**Jeanie Bourke - Re: 109 Fox St. BP# 2015-02051, CBL: 023 A008001**

**E TYP. COUNTER DETAIL**  
 1 1/2" = 1'-0"

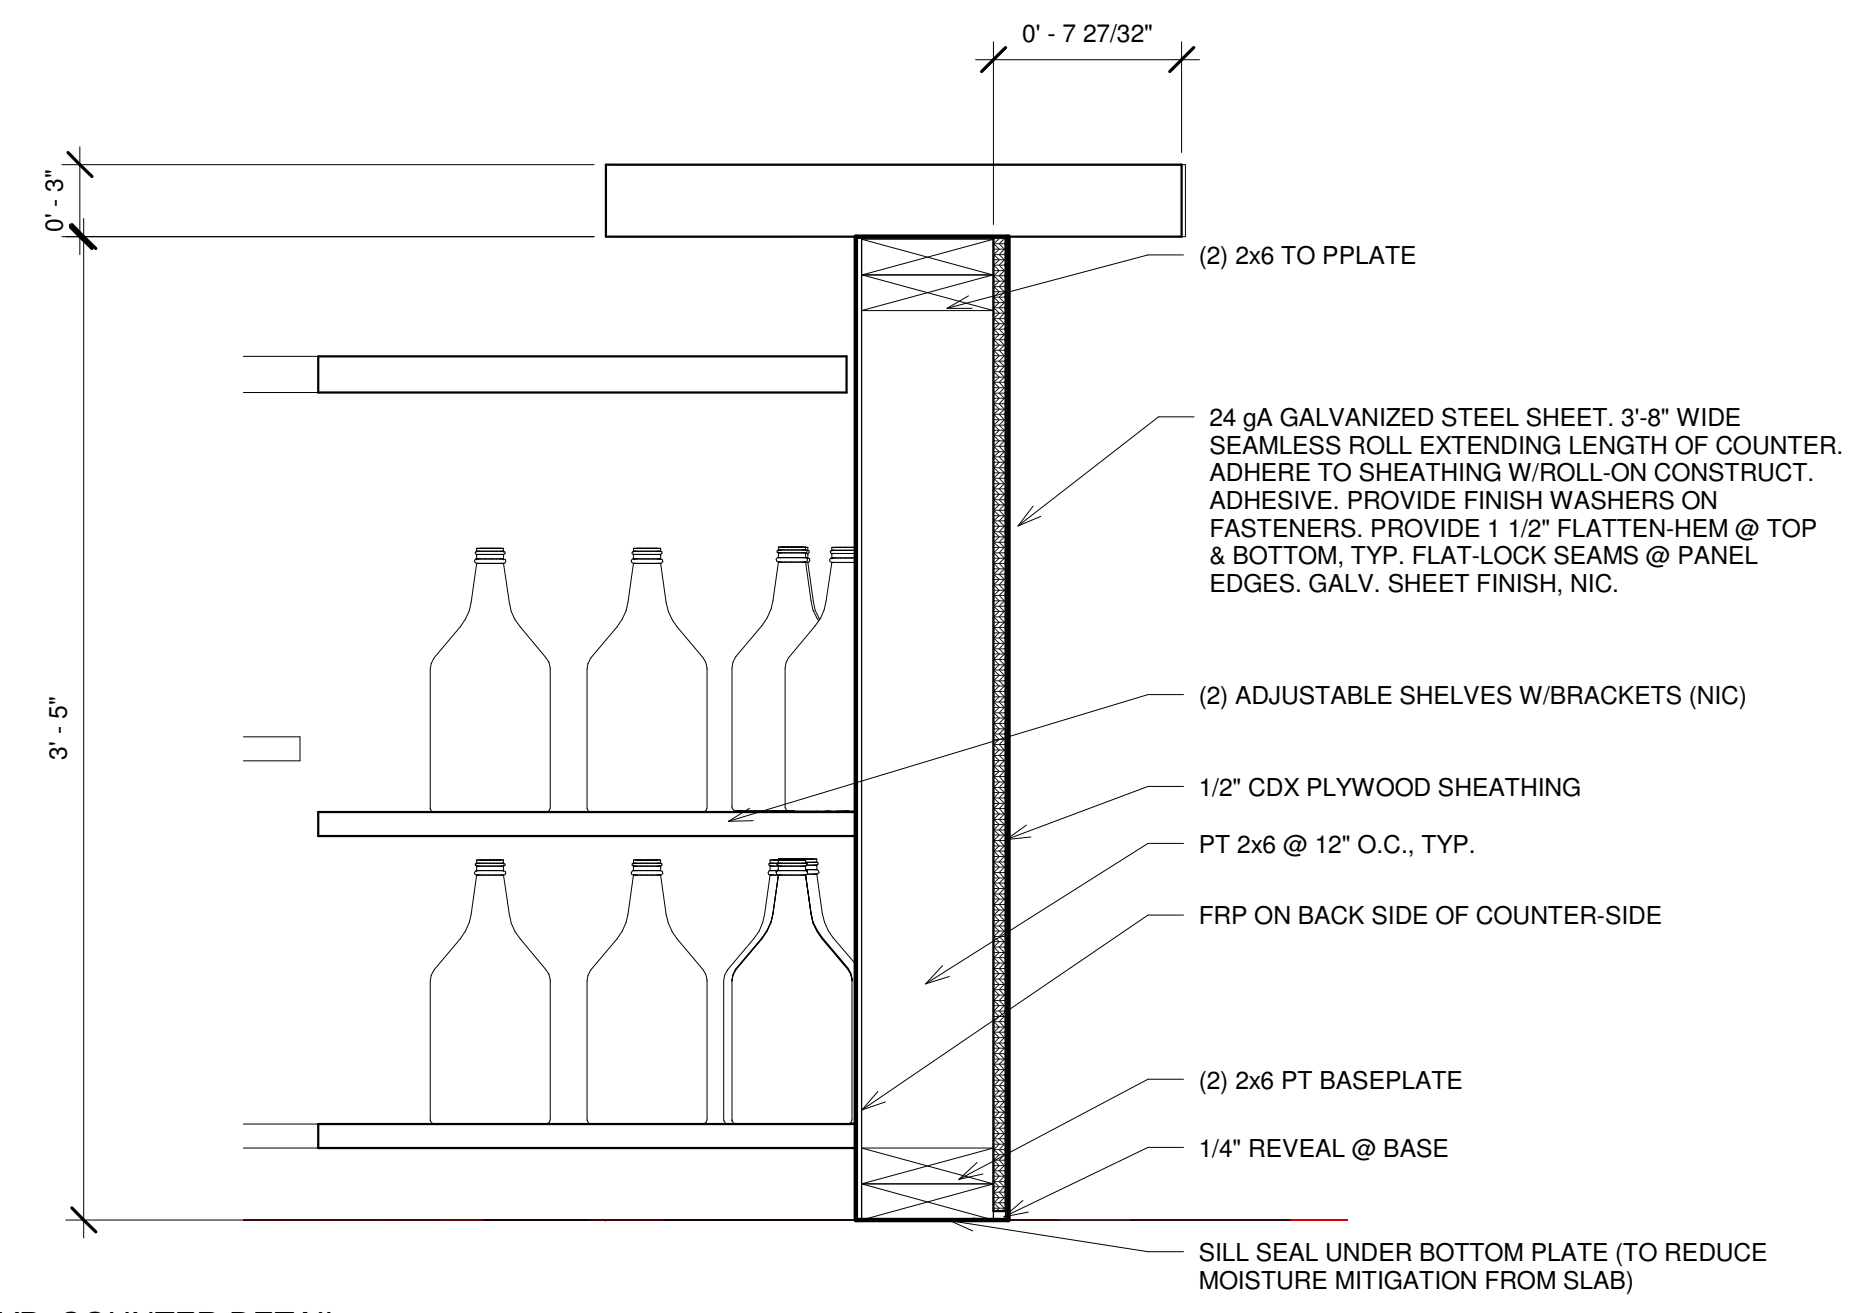
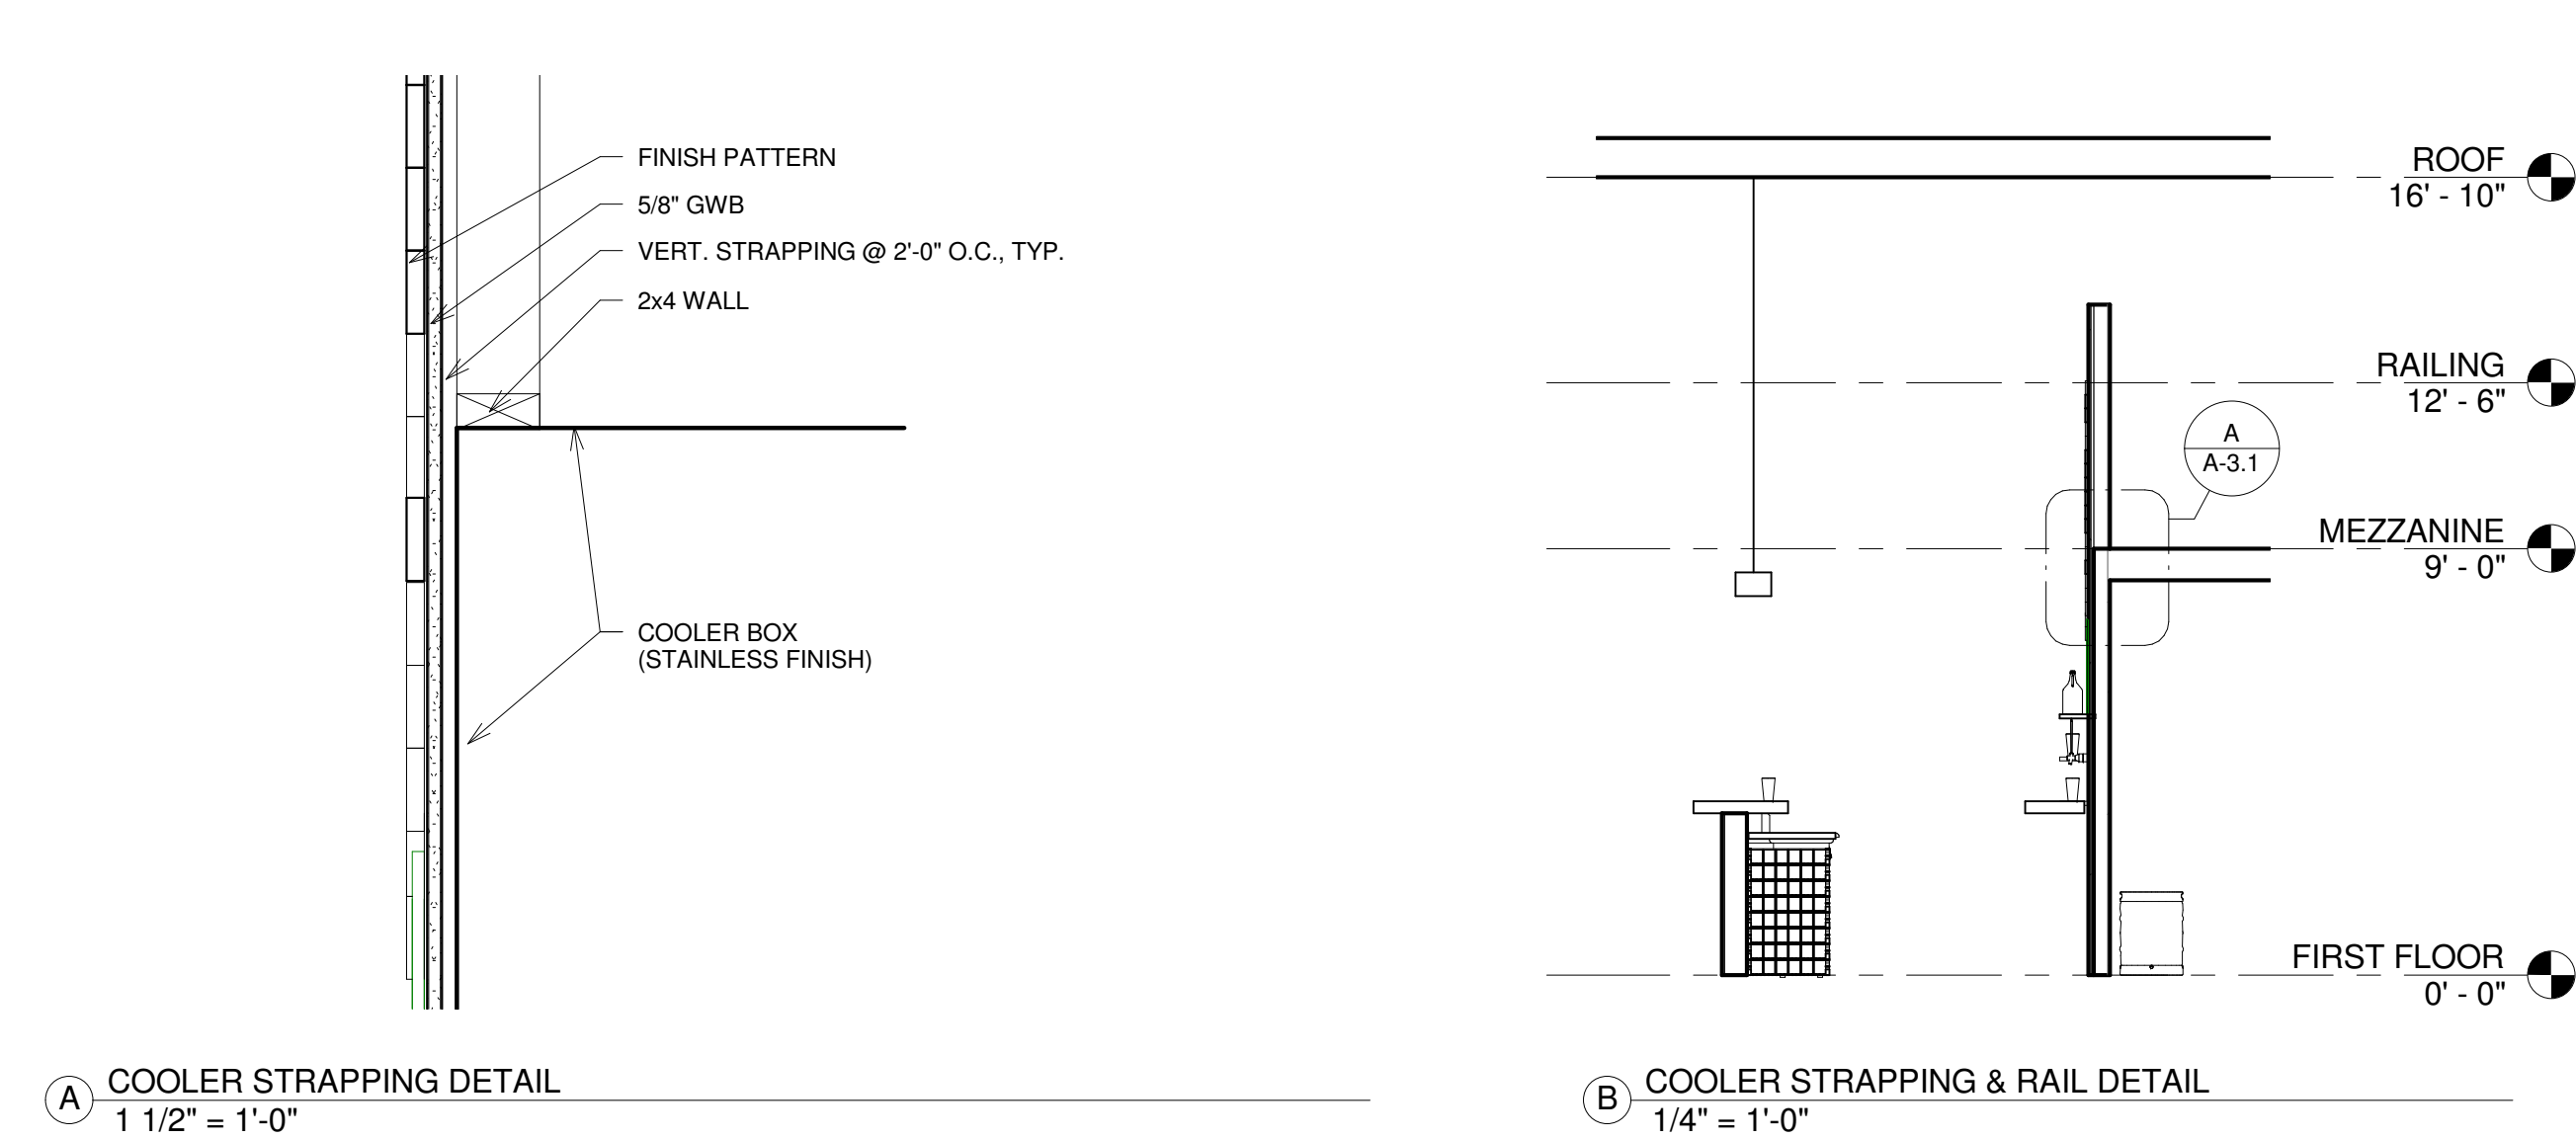
Per our earlier conversation I also spoke to Jill Johanning concerning the service counter height. She recommended 6'-0" in length as a reasonable amount and was pleased to hear you had referenced their document in your review. I also followed-up with the ICC regarding your comment on the IECC requirement for a vestibule per IECC section 502.4.7 and they confirmed that we do not meet the exceptions to that regulation. However, they did note that the production-side man door and existing main entrance (double door) would not need vestibules since they are grandfathered in. These doors also are expected to see the vast majority of foot traffic in the building since the single-man door is functioning as a second means of egress for the assembly space. Signage will encourage customers to enter through the existing entrance, nearest parking. The brewery also creates heat during production that dramatically reduces the facilities reliance on fossil fuels for heating. Off-site storage of the majority of the finished product also means they seldom air condition during the summer.
